Application for a non-material amendment following a grant of planning permission.
Town and Country Planning Act 1990

SIDE AND REAR EXTENSIONS AND CREATION OF FIRST FLOOR

EP/139/16/HH

WE WISH TO MAKE AN AMENDMENT TO THE DESIGN OF THE FRONT DOOR AND THE LANDING WINDOW ABOVE.

DRAWN BY AP	CHECKED BY AP	DATE 11/02/16
SCALE (@ A1) As indicated	PROJECT NUMBER APA/024/CLOSE	
DRAWING NUMBER A101 Rev H		REVISION

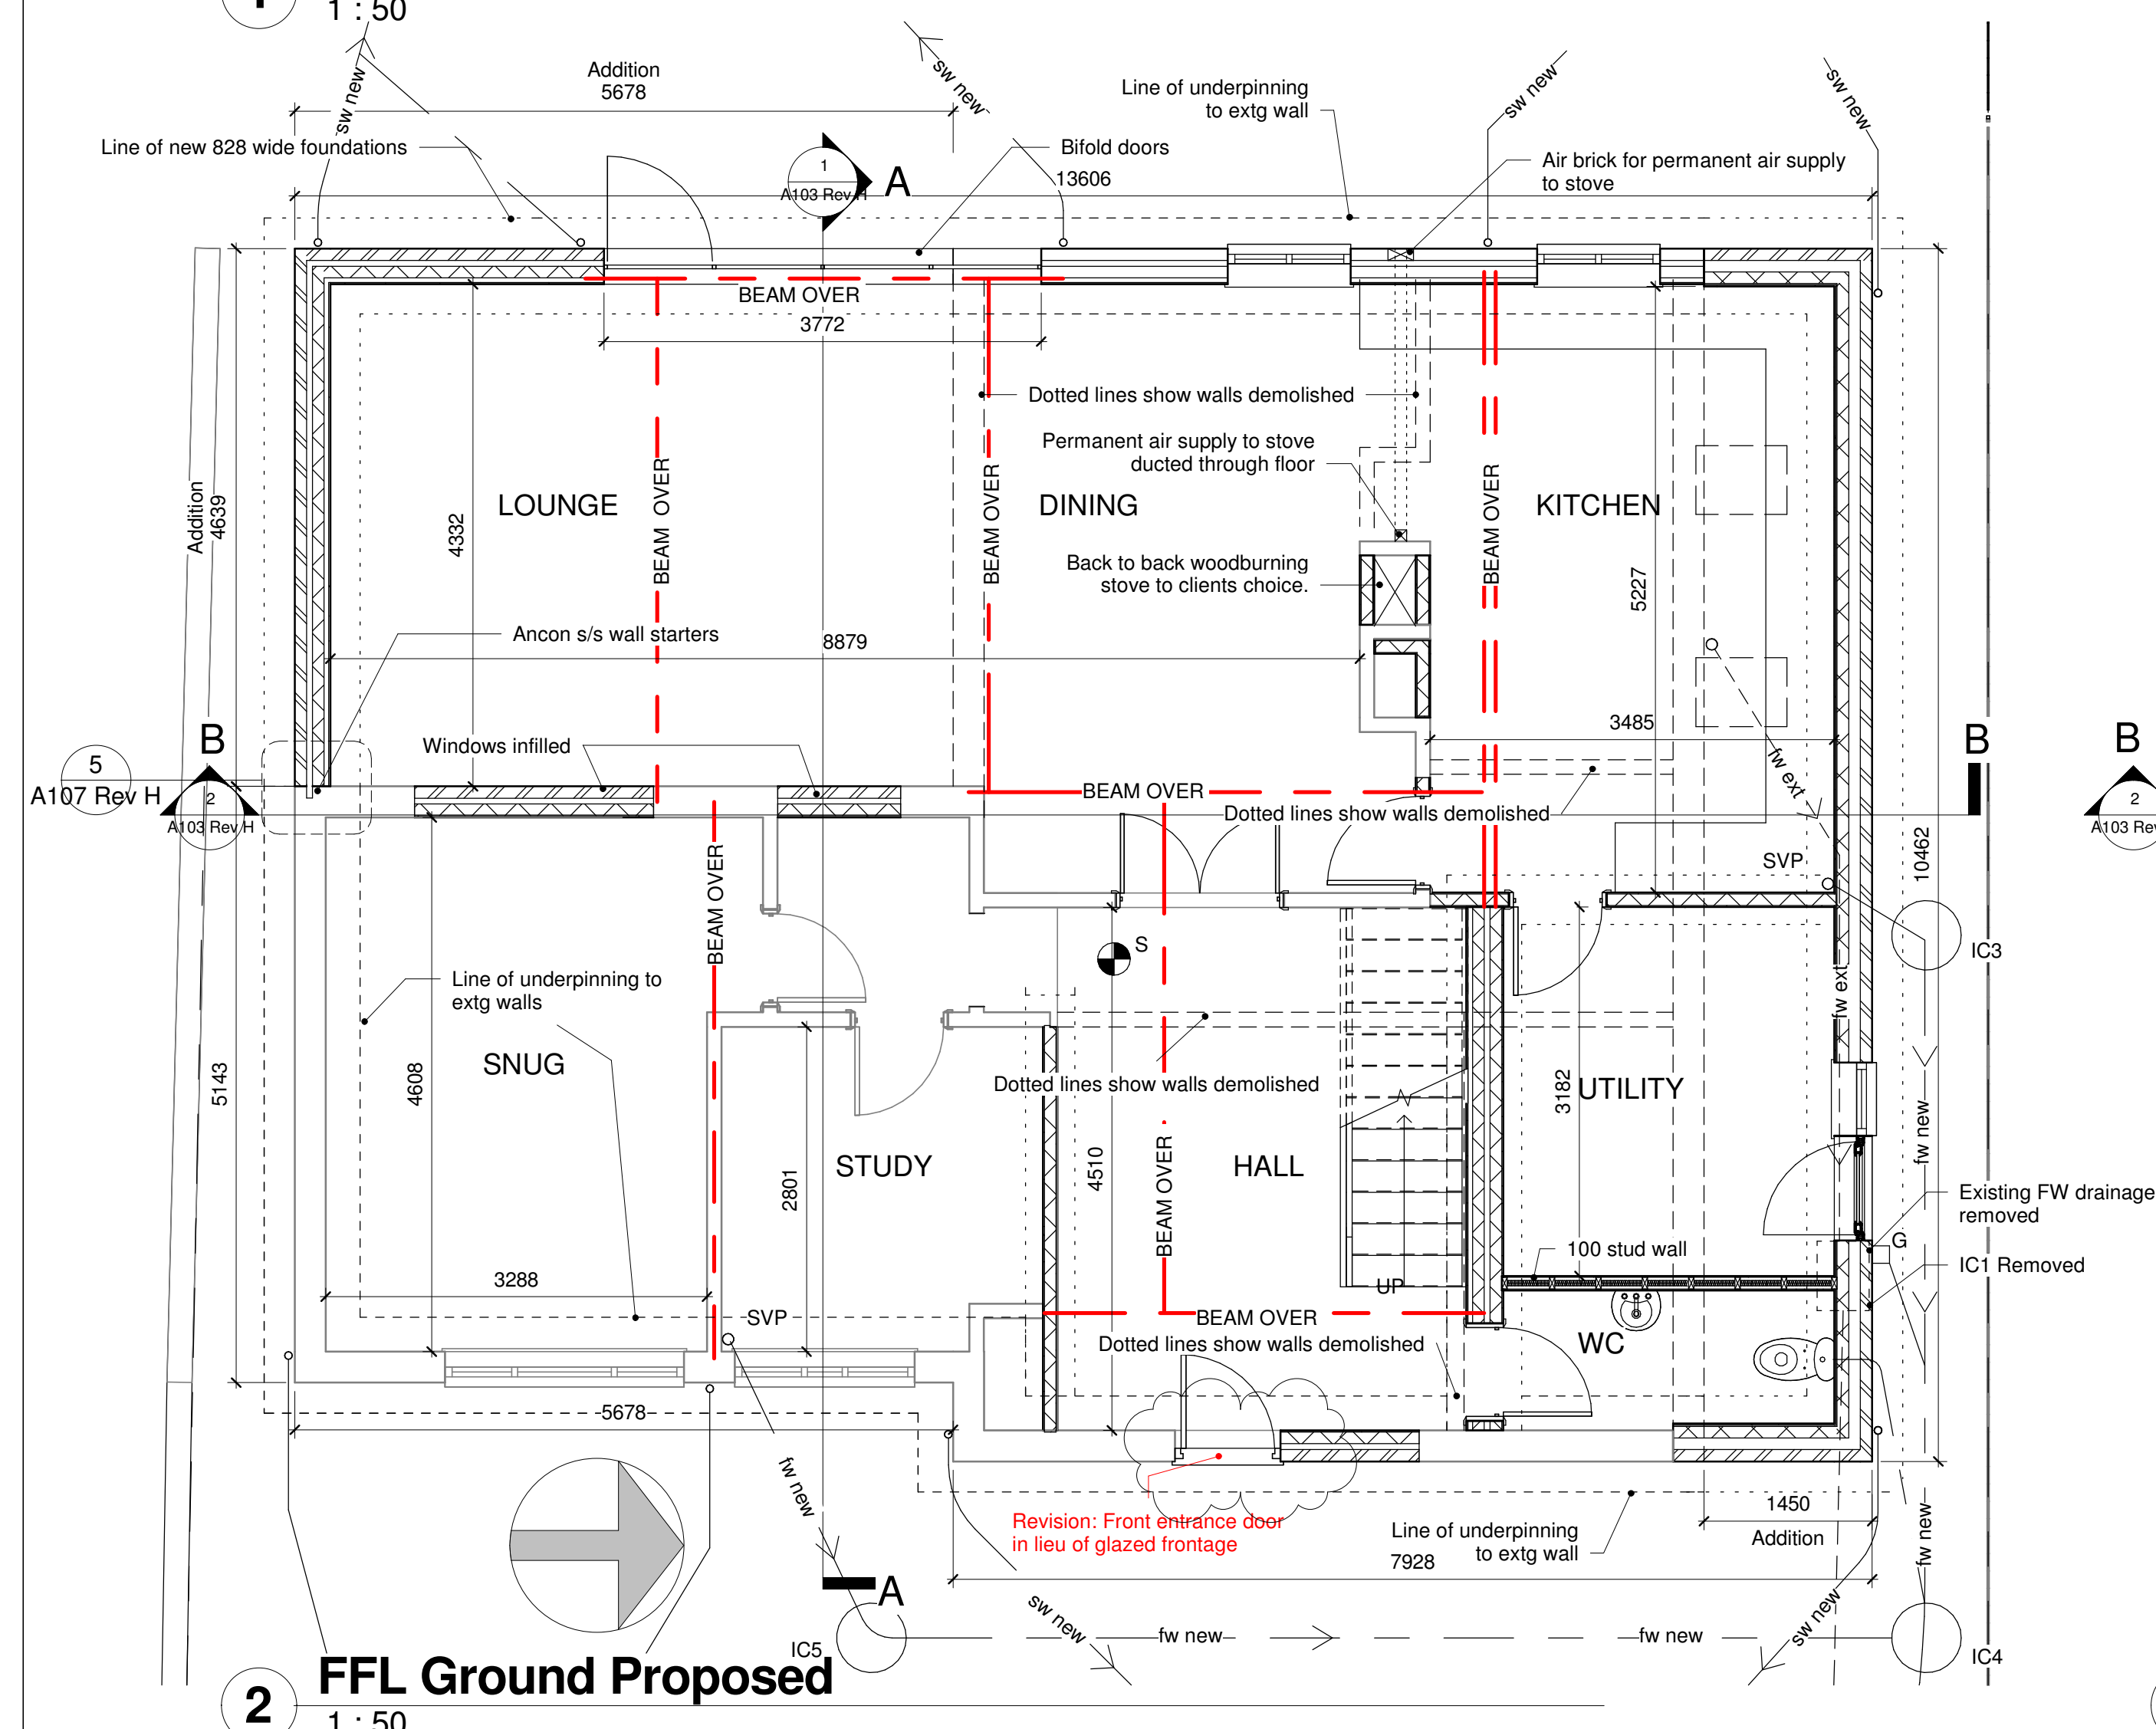
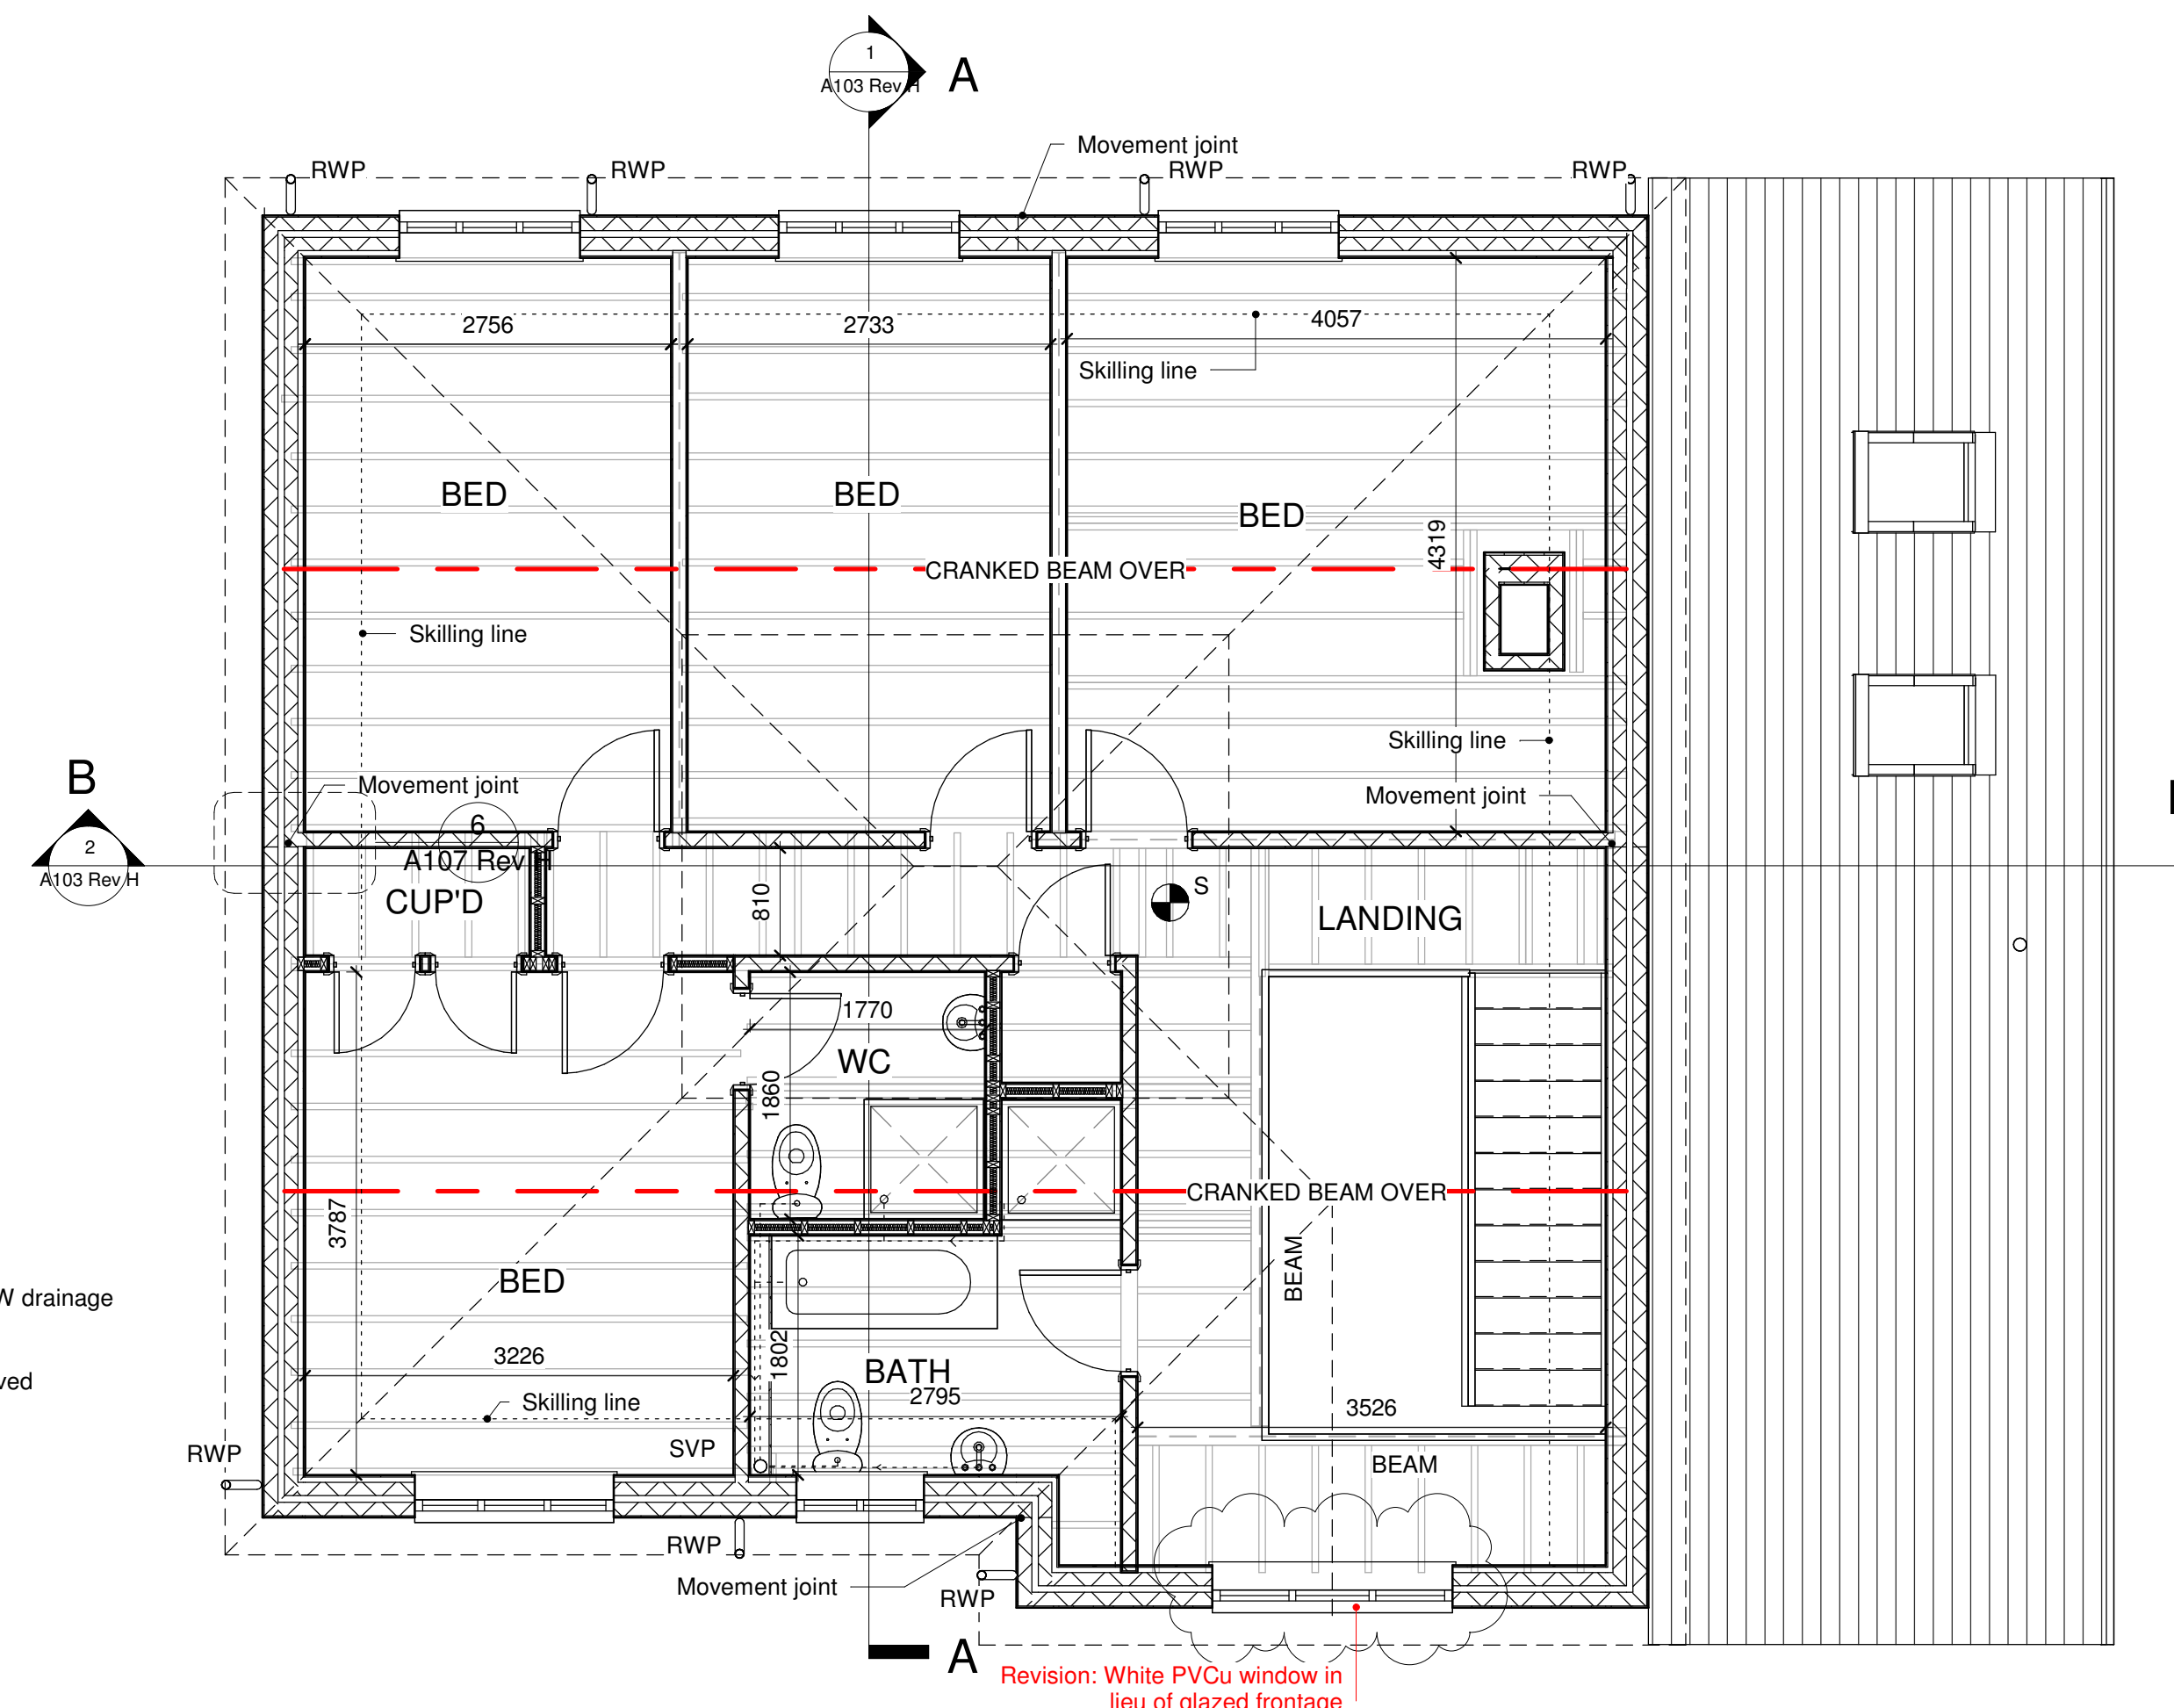
THE FULL HEIGHT GLAZING ON THE FRONT ELEVATION IS TO BE REPLACED WITH A SINGLE ENTRANCE DOOR AND WINDOW ABOVE.

2 East (Front) Elevation Proposed
1 : 100

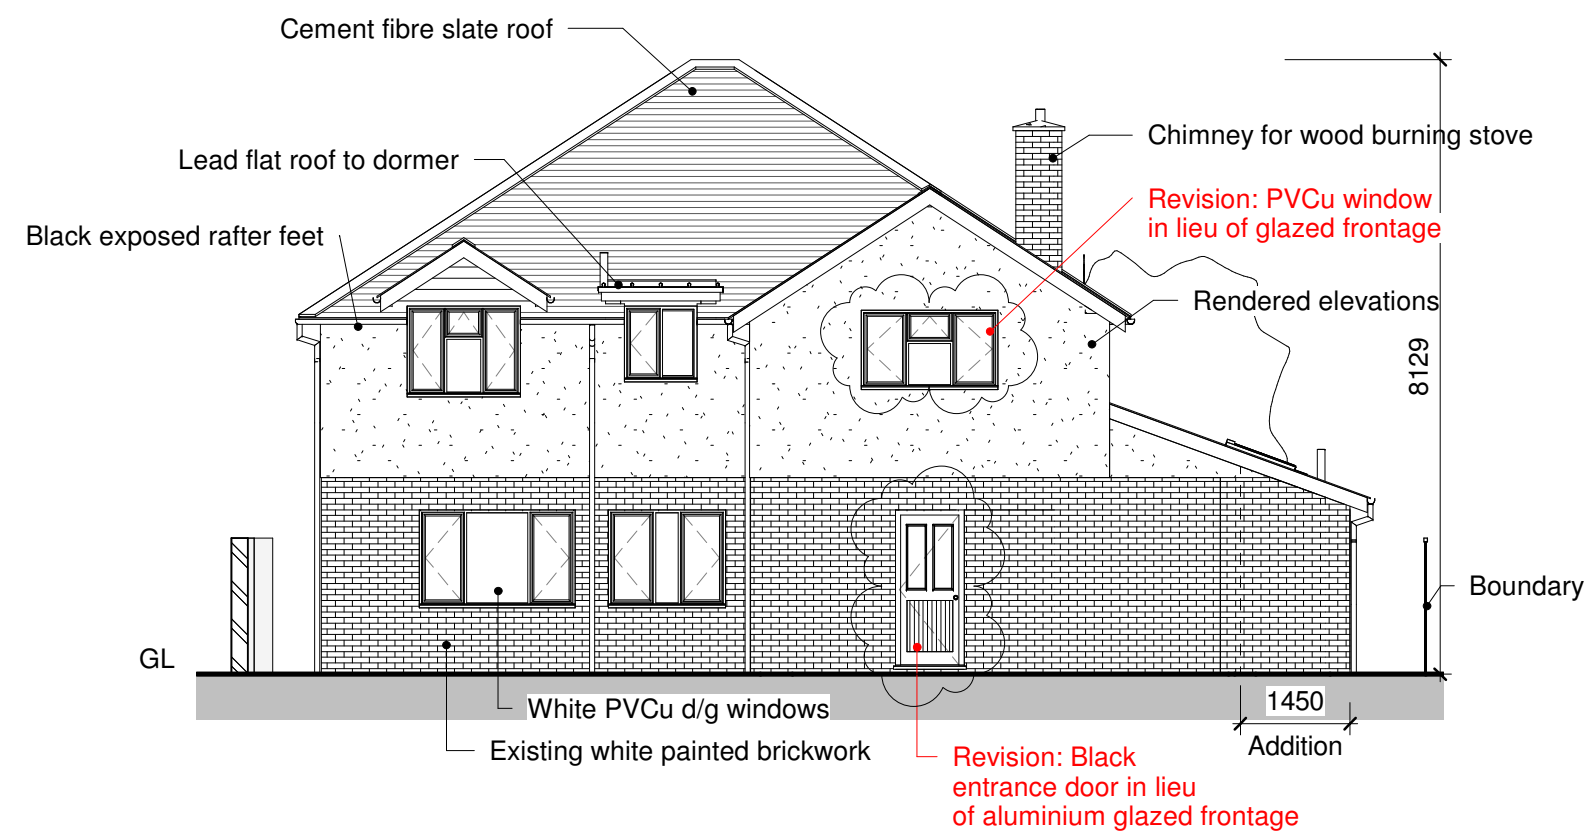
THE CHANGE WILL GIVE THE HOUSE A MORE TRADITIONAL LOOK.
THE PROPOSED ALUMINIUM GLAZED FRONTAGE WOULD HAVE BEEN VERY EXPENSIVE AND COMPLEX TO BUILD STRUCTURALLY. WE REALISED THIS ONCE WE ENGAGED A STRUCTURAL ENGINEER.
